Your Ref: OWQC23943
Our Ref: BE/79/19/PL
Please ask for:
Ms M Tomalova

Single-storey bungalow on land adjacent to Walnut Tree Cottage & reinstatement of double garage to Walnut Tree Cottage from annexe/holiday let - This application may affect the character and appearance of the Shripney Conservation Area
Land Adjacent to Walnut Tree Cottage Shripney Lane Shripney

Thank you for your internet comments made on 7th August 2019 which has been recorded as 'an objection' with the comments as follows:

Drawing Title
North Elevation
As Proposed

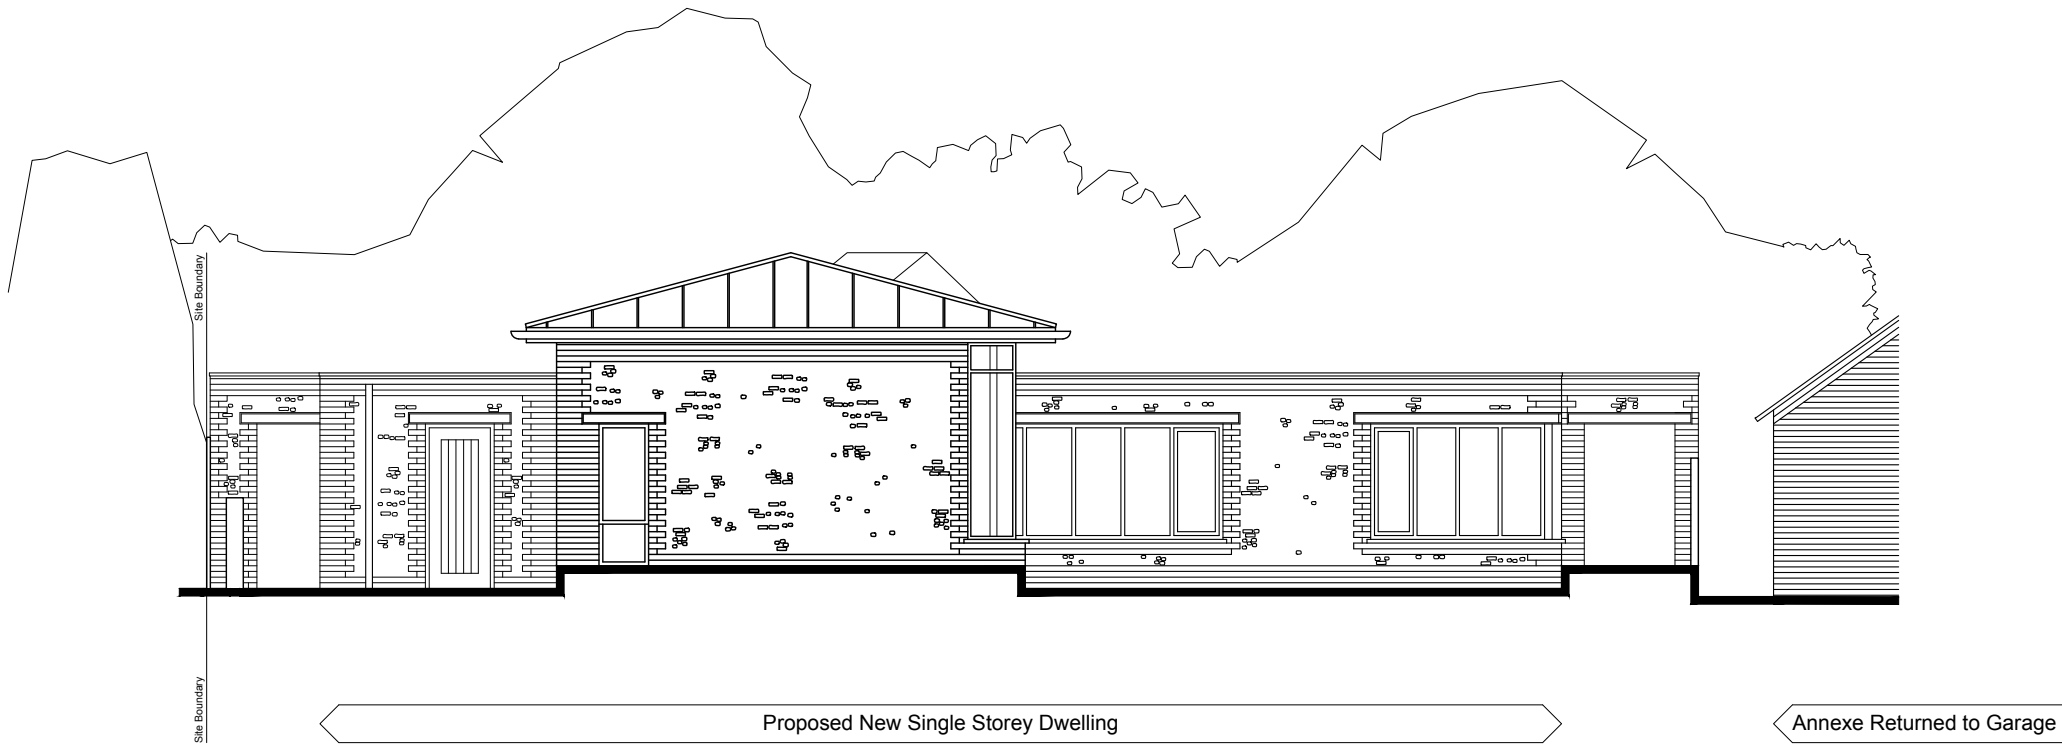
Bersted Neighbourhood Plan Policies ES1 design of the new development and ES5 building design members felt that the design was too modern and did not enhance or integrate with the surrounding character of the Shripney Conservation Area.
